## EL PASO COUNTY GRADING AND EROSION CONTROL PLAN CHECKLIST

PROJECT NO.
196106001
SHEET
C1.24

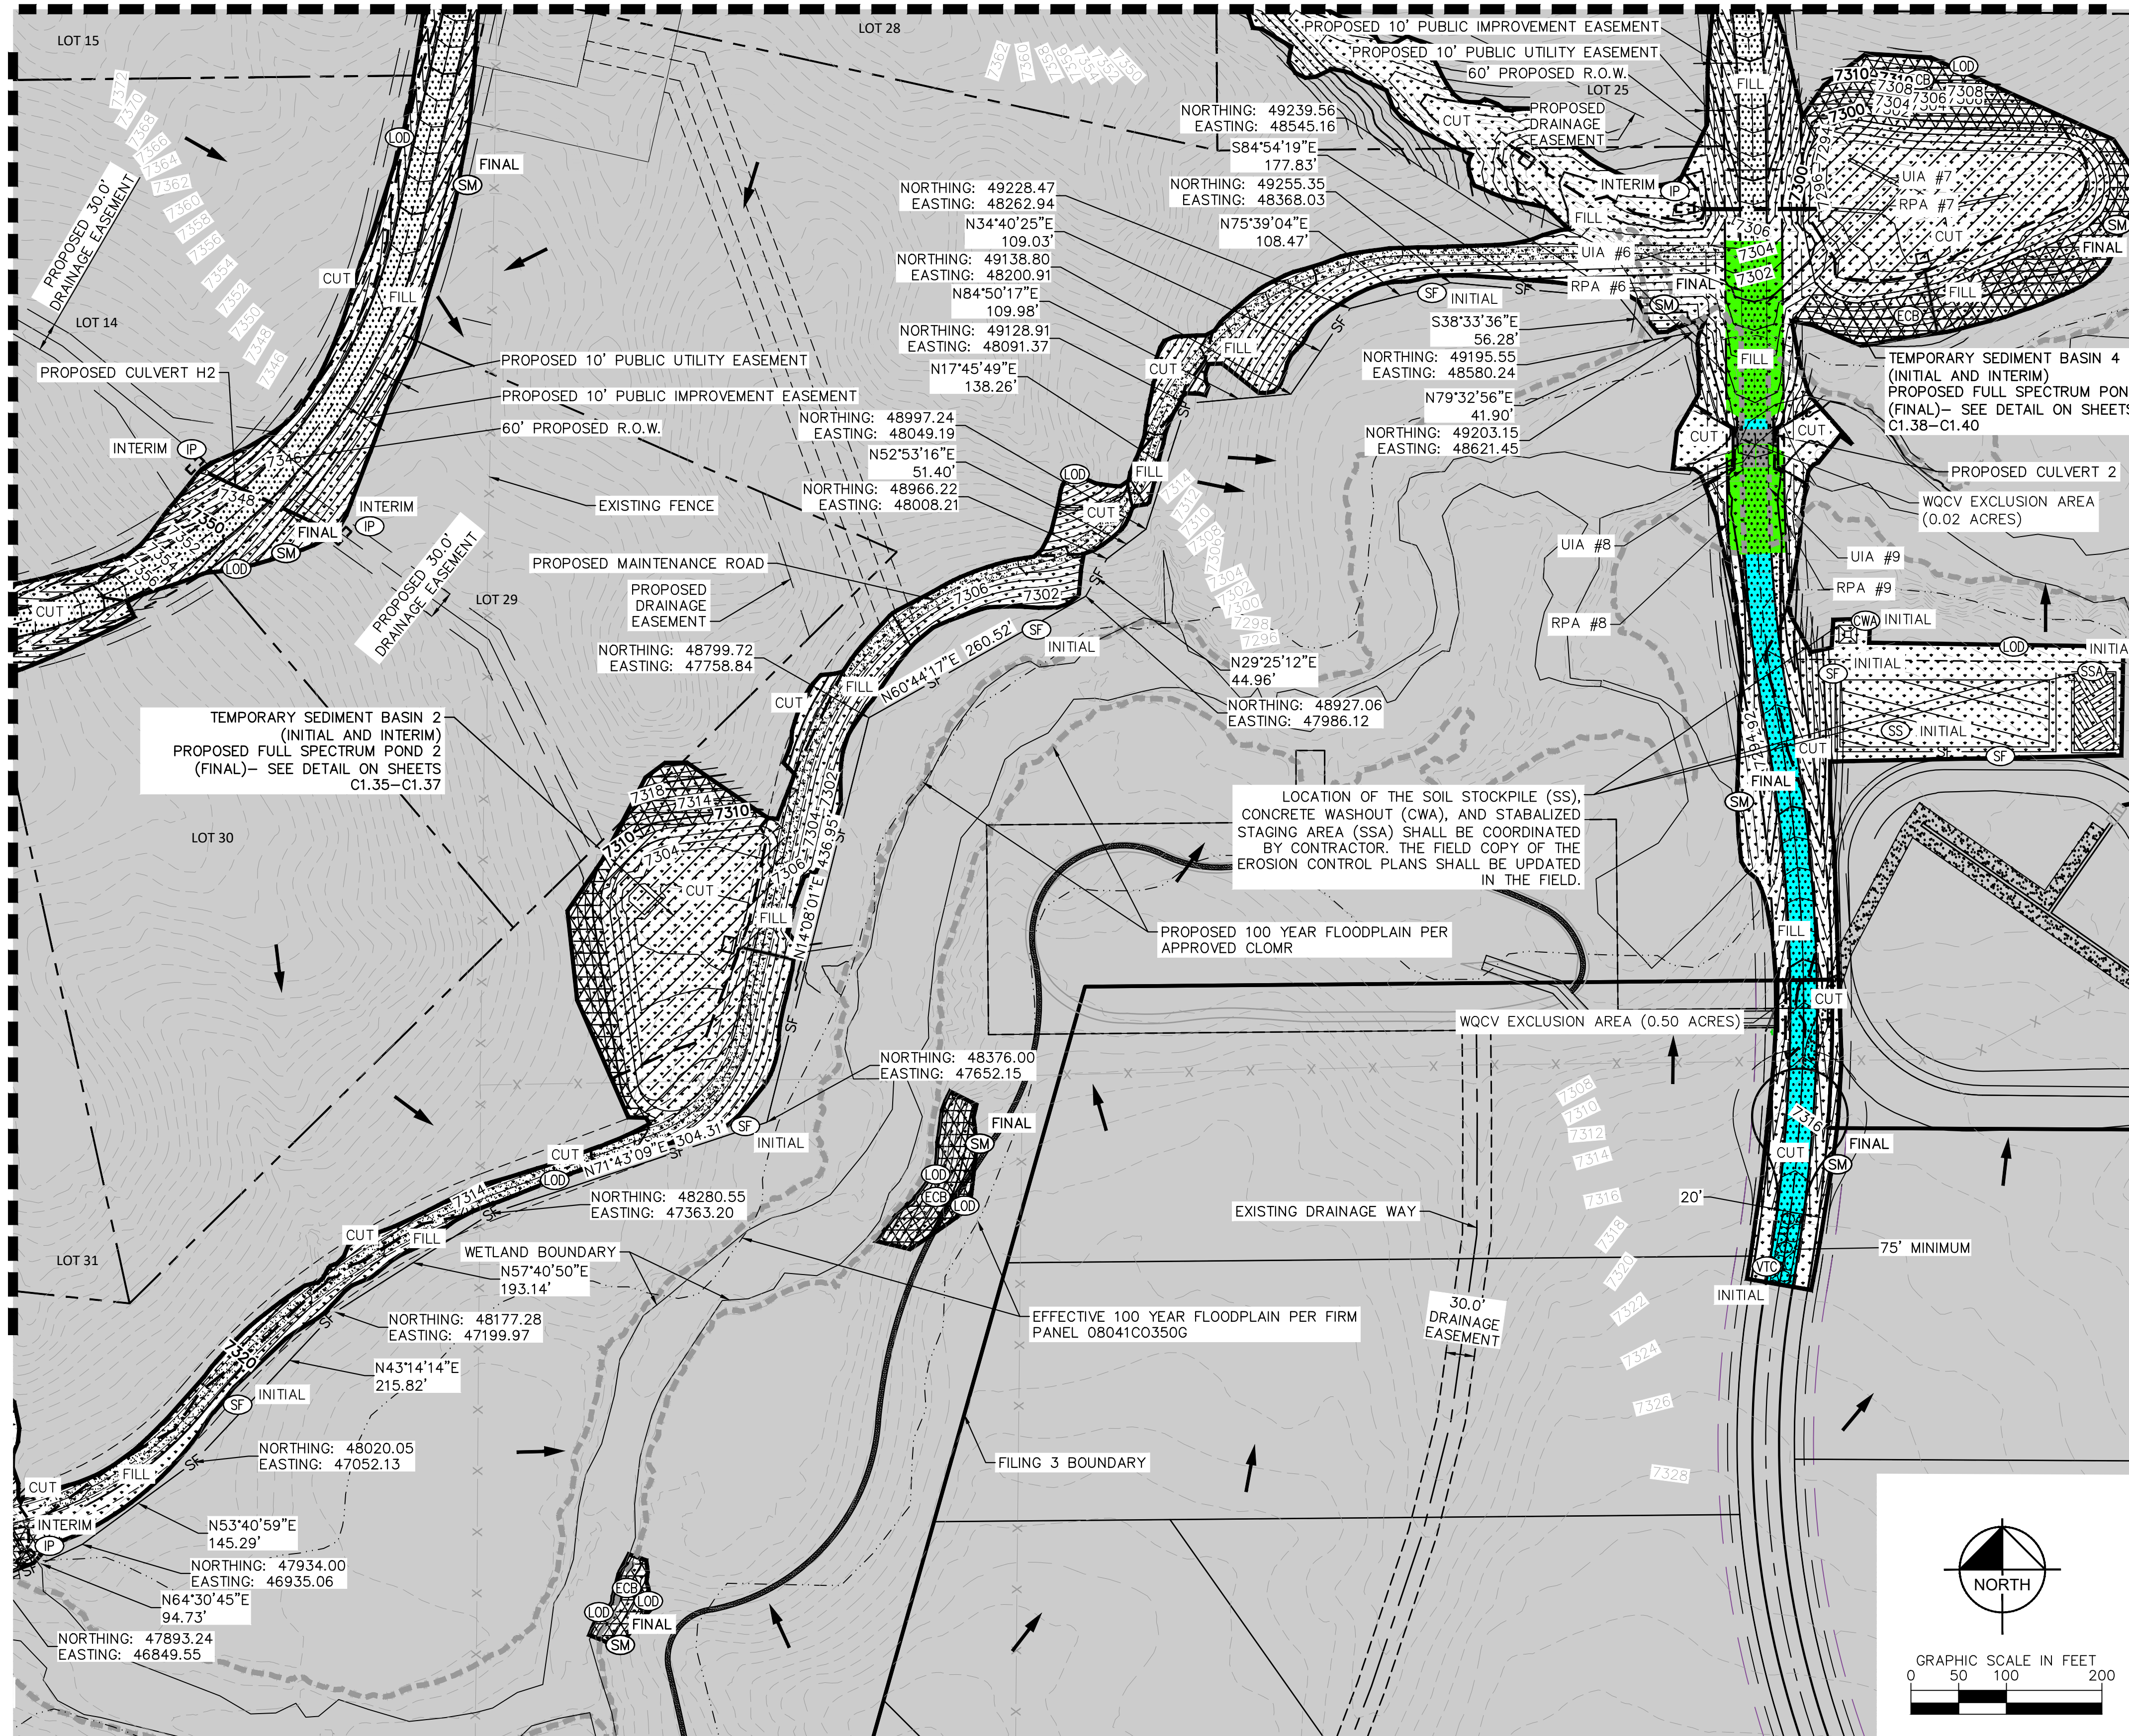
Update GEC Plans to Plat to show Runoff Reduction areas.
